Subject: FW: Response To Application Number AB/135/20/OUT at Land at Ford Road Arundel

In response to my previous request for information the following has been provided/discussed with the applicants transport consultant:

VEHICLE SPECIFICATION:

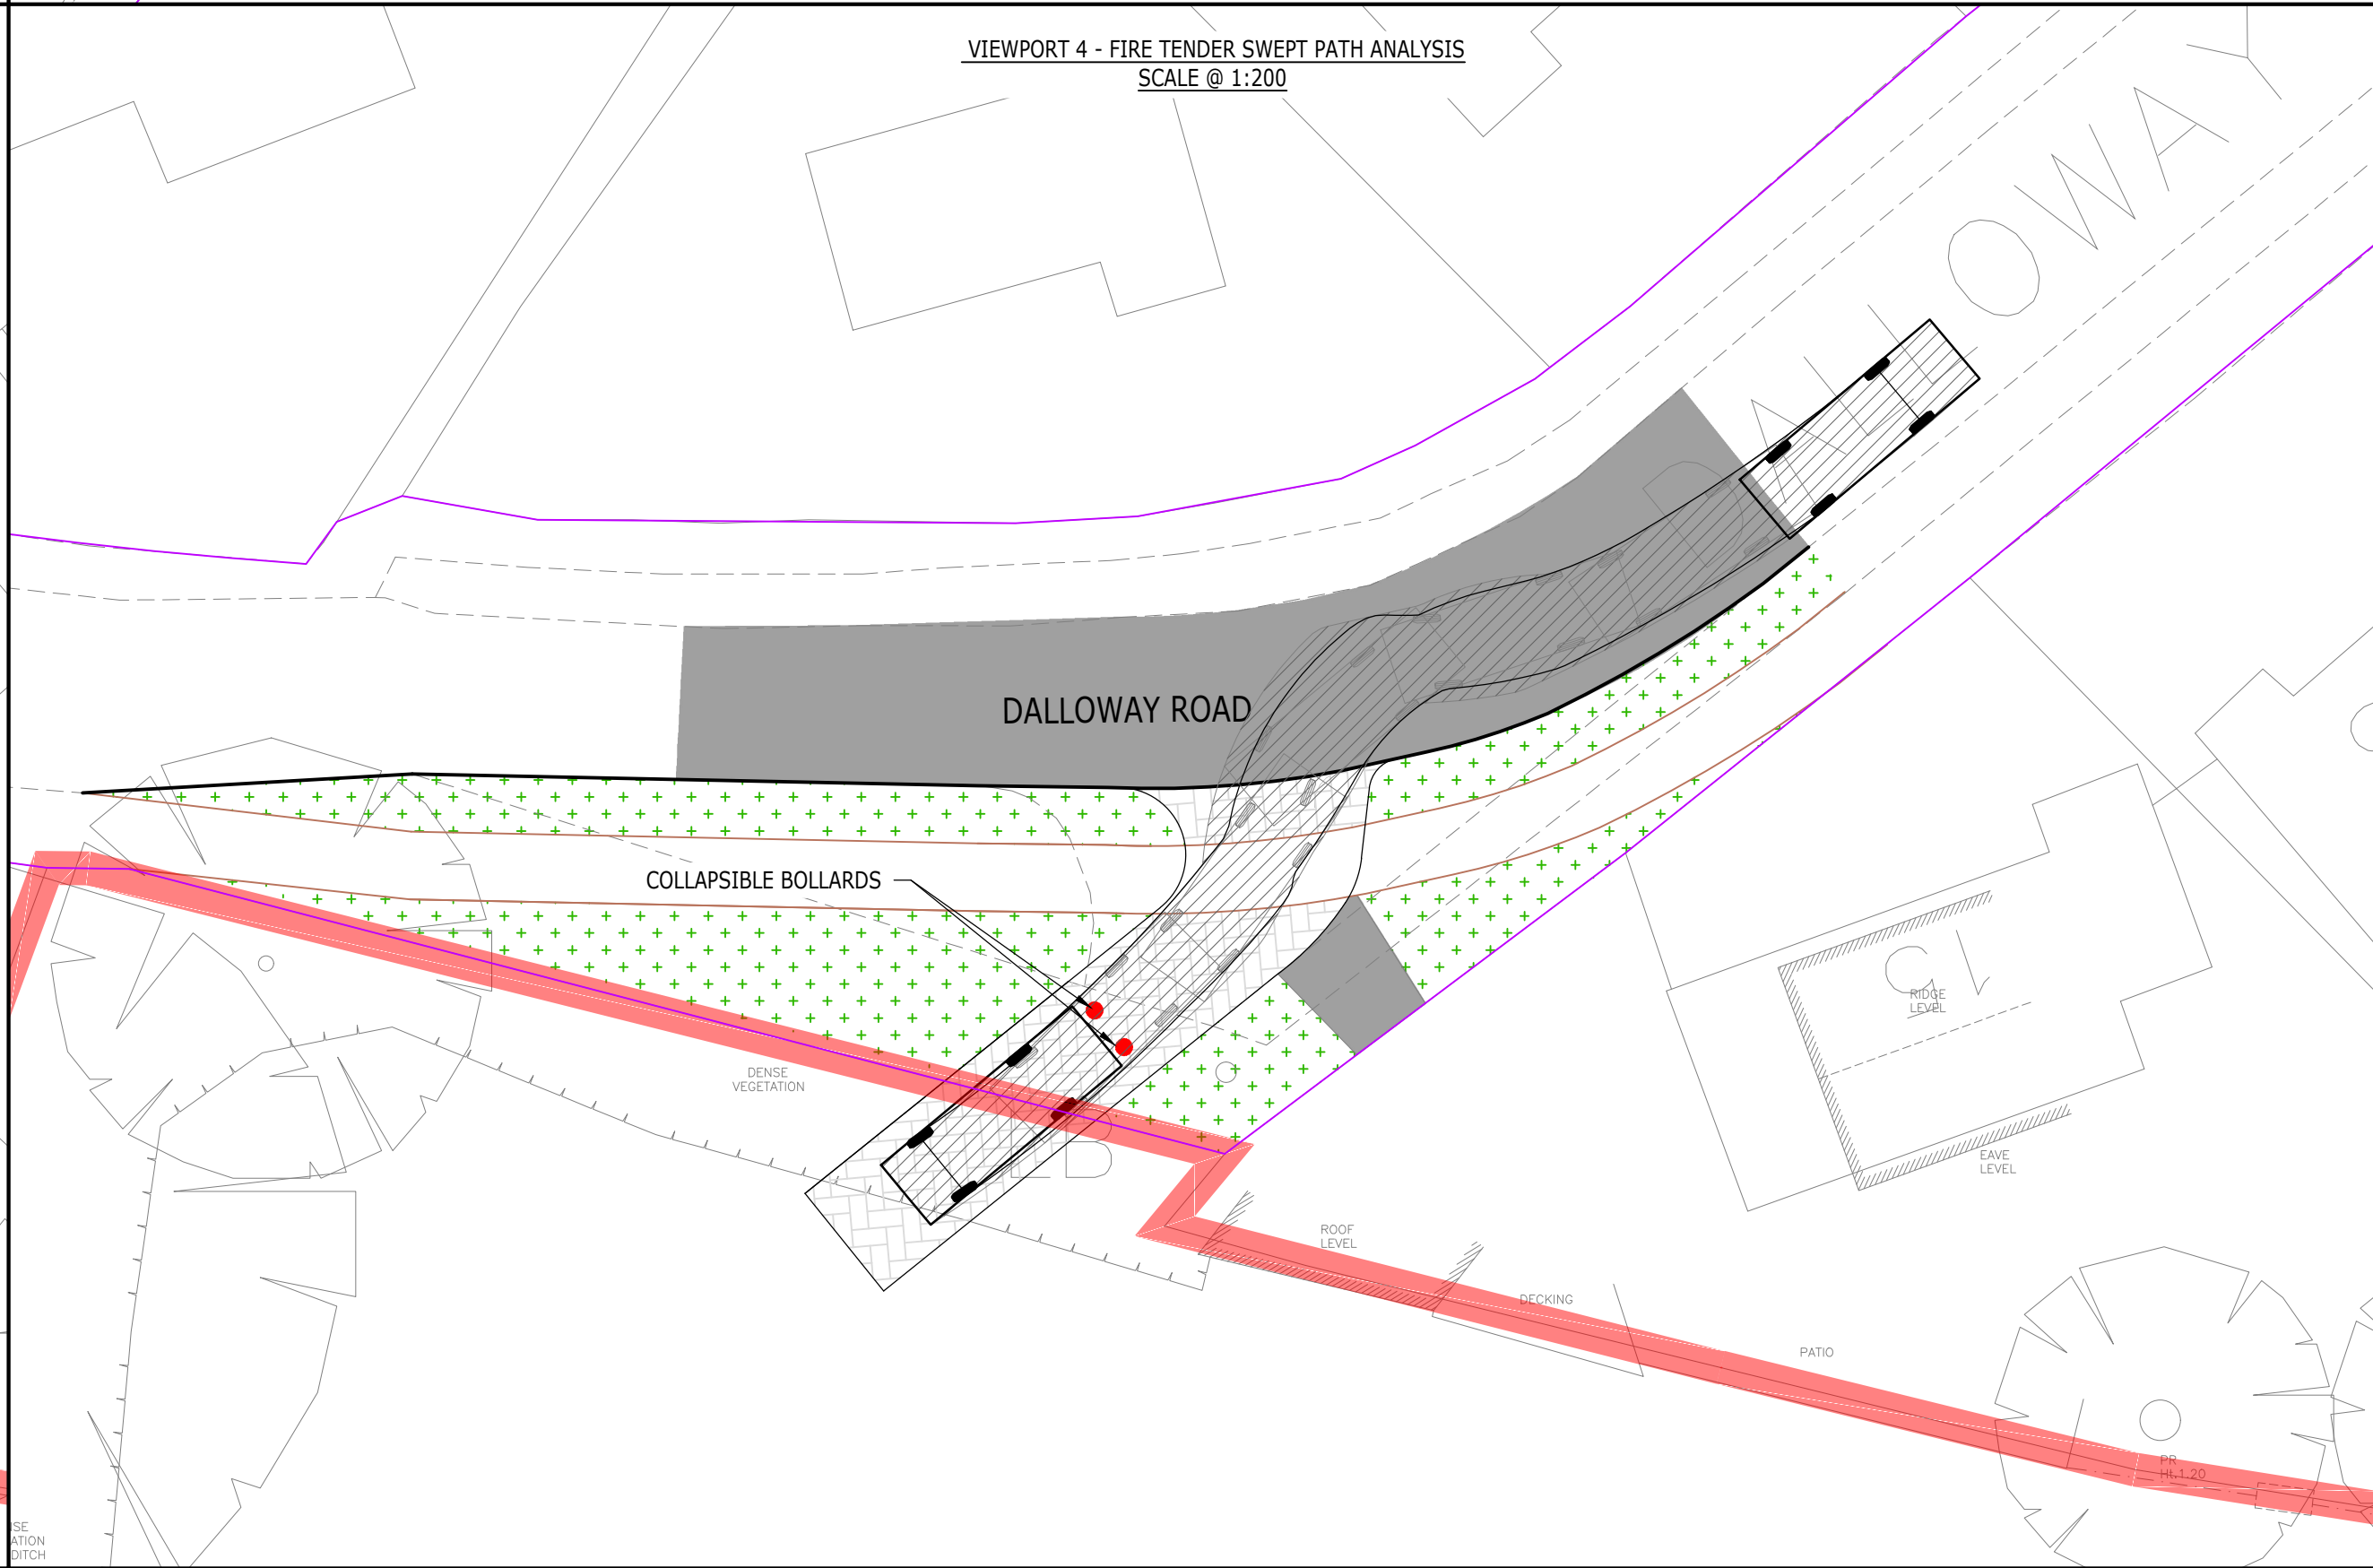
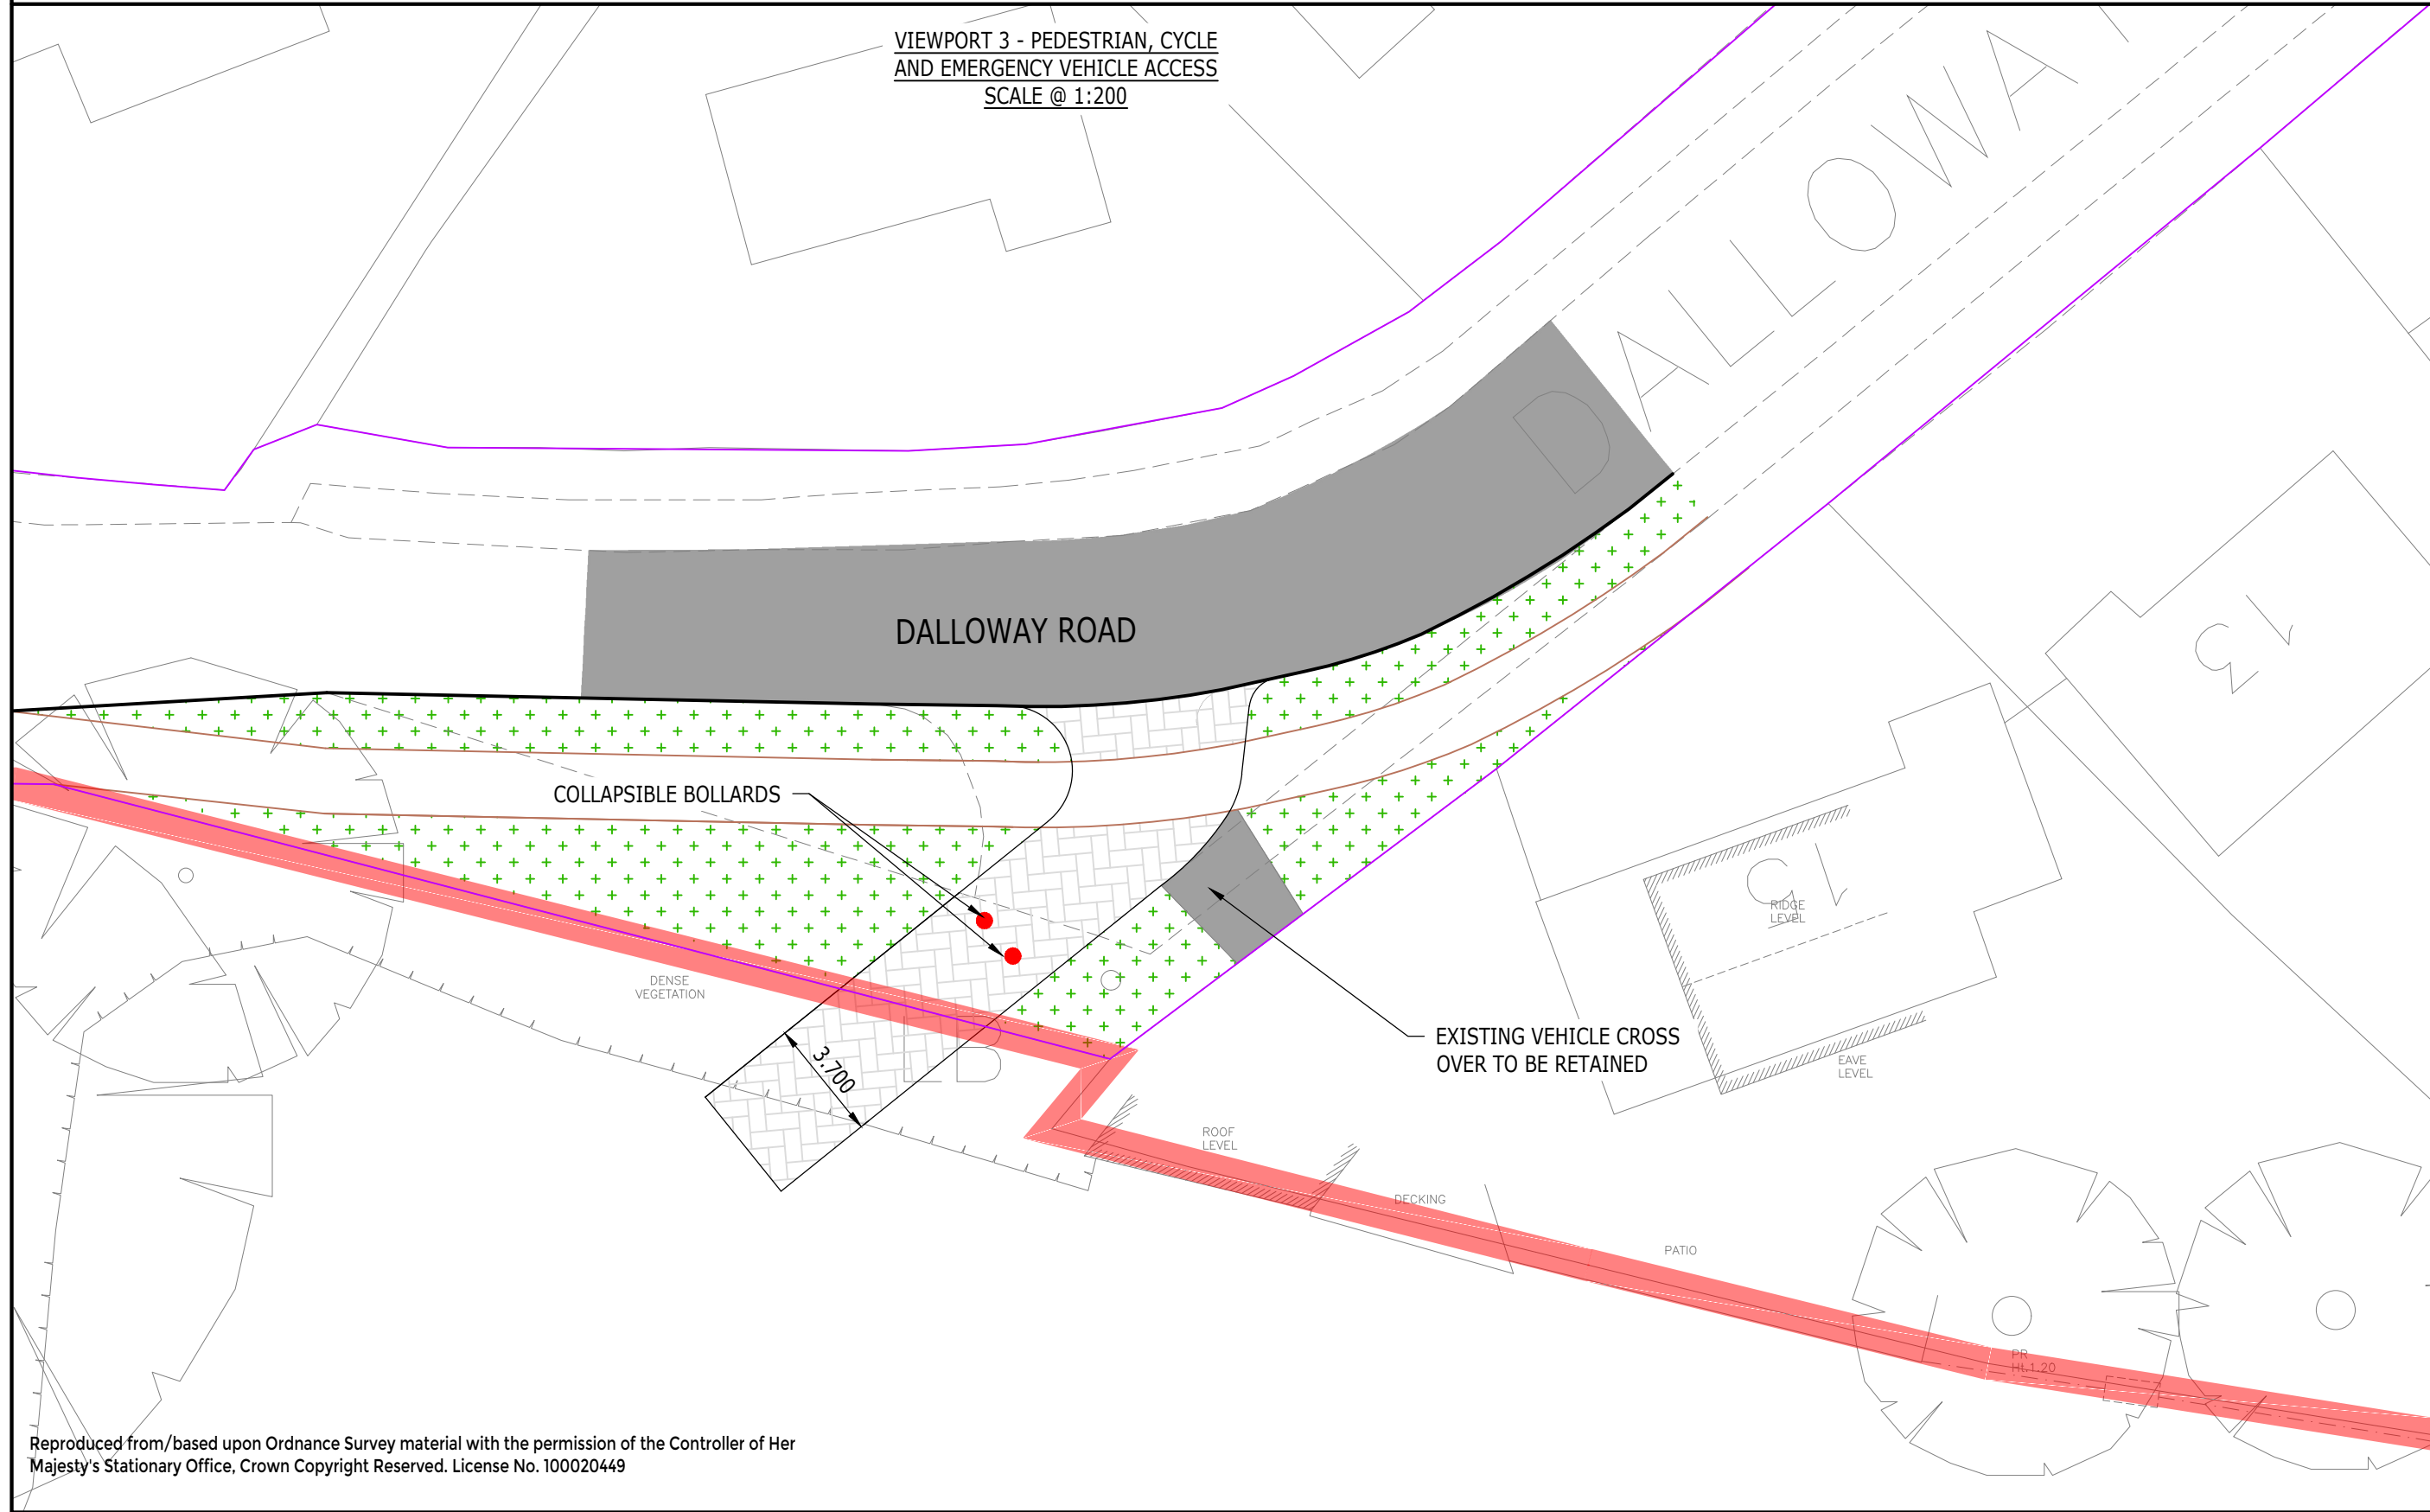
1. Details of pedestrian connectivity/identification of pedestrian infrastructure improvements /pedestrian visibility splays.
- Coloured access plan has been provided which details a footway provision along Ford Road to link with existing provision
- Identification of improvements along the route to local bus stops
- Provision of additional footway and uncontrolled pedestrian crossing with tactile paving for east-west pedestrian movements at the junction of Dalloway Road/Stewards Rise.
- Provision of additional footway and uncontrolled pedestrian crossing with tactile paving for north-south pedestrian movements on Dalloway Road to the west of the junction with Torton Hill Road.

A plan of these has been requested.

- Through discussions it is agreed details of the links to the south will be conditioned (within access timetable condition)

No part of the development shall be first occupied until such time as a timetable covering the construction of the vehicular and non-vehicular accesses serving the development has been submitted to and approved in writing by the Local Planning Authority. The accesses shall thereafter be constructed in accordance with the approved timetable and details shown on the drawing titled site access arrangement and numbered 173483-002 Rev E.
